Fire Marshal Division

December 15, 2020

Re: KB Model Home
Windy Farm Drive
Fuquay-Varina, NC 27526

Application Number BCOM2012-0007

CONSTRUCTION PLAN

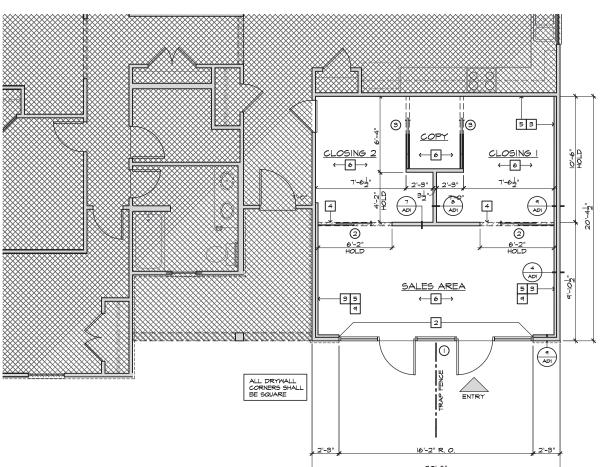
- **Size of Doors**
 - The minimum width of each door opening shall be sufficient for the occupant load thereof and shall provide a clear width of 32 inches.
